**SECTION 4.55(1A) MODIFICATION APPLICATION – SSD 6966
BUILDING R5, ONE SYDNEY HARBOUR, BARANGAROO SOUTH**

This modification application has been prepared by Ethos Urban on behalf of Lendlease (Millers Point) Pty Ltd (Lendlease), pursuant to section 4.55(1A) of the *Environmental Planning and Assessment Act 1979* (EP&A Act) to modify Development Consent SSD 6966 relating to Residential Building R5 at Barangaroo South (the site).

The proposed modifications relate to the reallocation of car parking spaces and associated storage cages within the Stage 1B basement between Building R5 and Buildings R4A and R4B. No physical changes are proposed to the approved basement.

Drawing: BR5_ASD_PA1_1002
Date: 21.10.21 Revision: 21
\$4.55

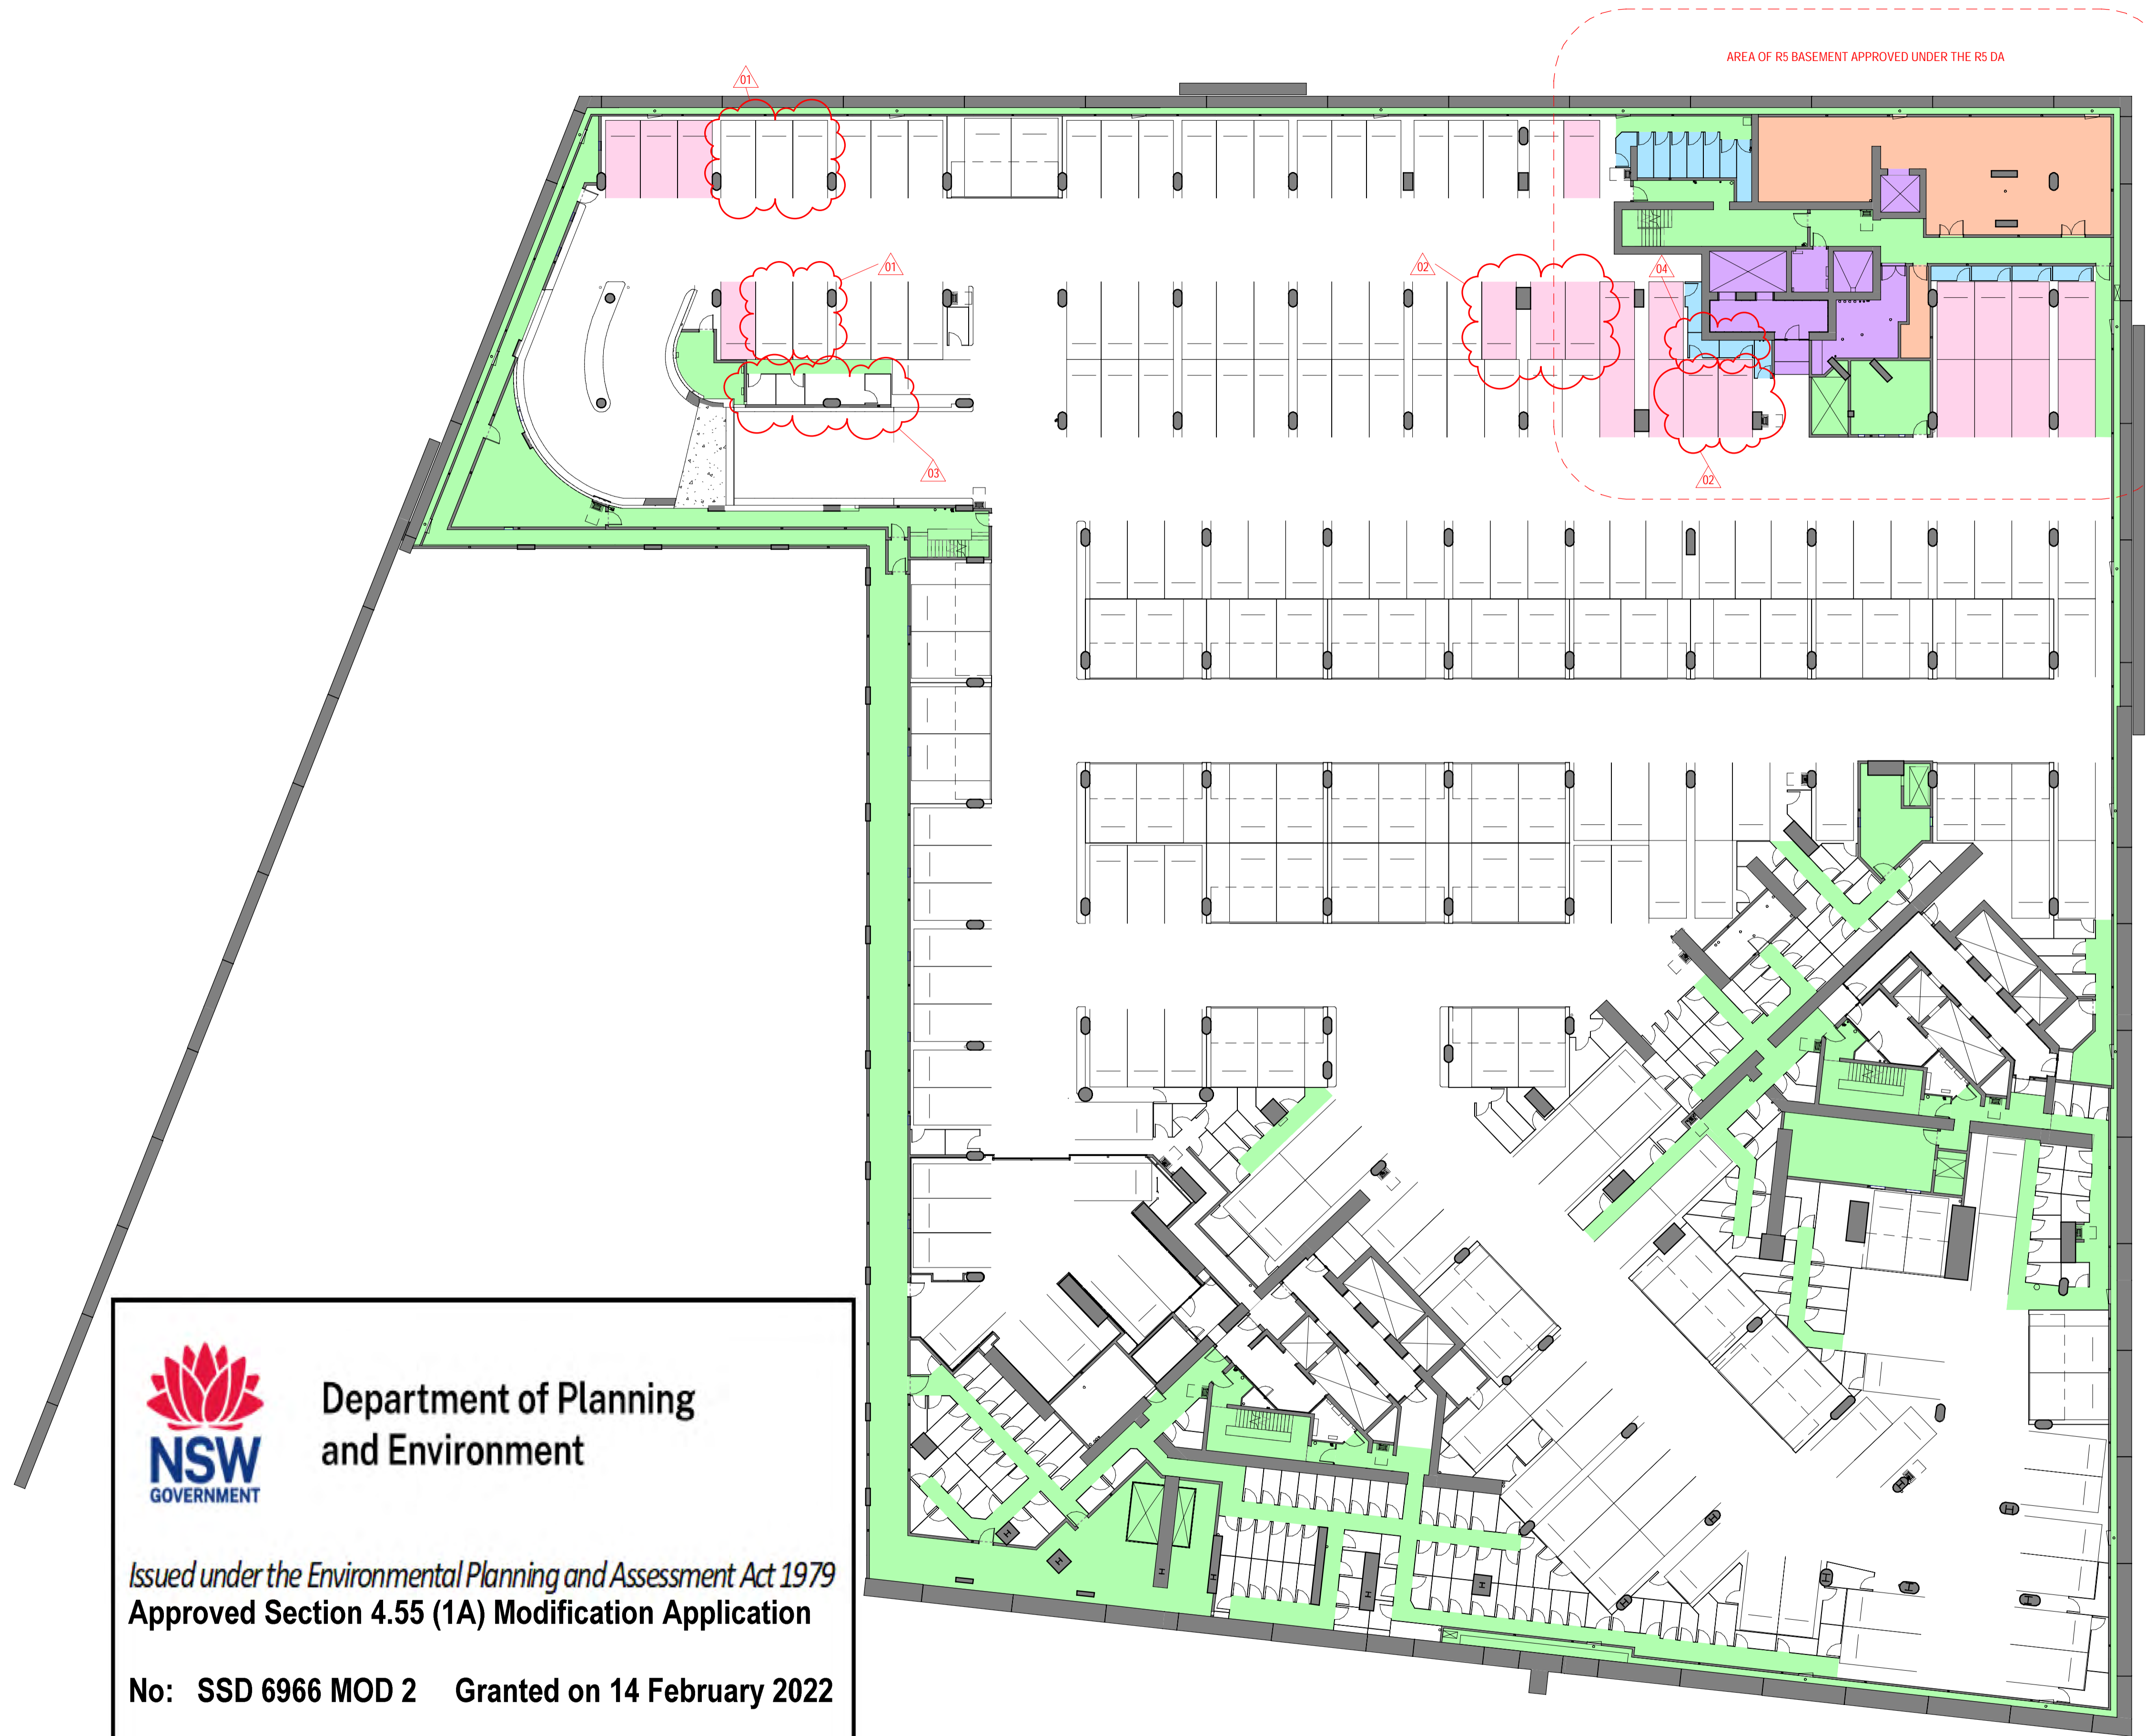
- Level B1: Reallocation of six car parking spaces and associated storage cages between Building R5 and Building R4B.
- Level B2: Reallocation of five car parking spaces and associated storage cages between Building R5 and Building R4A.
- Level B3: Reallocation of three car parking spaces with between Building R5 and Building R4A.
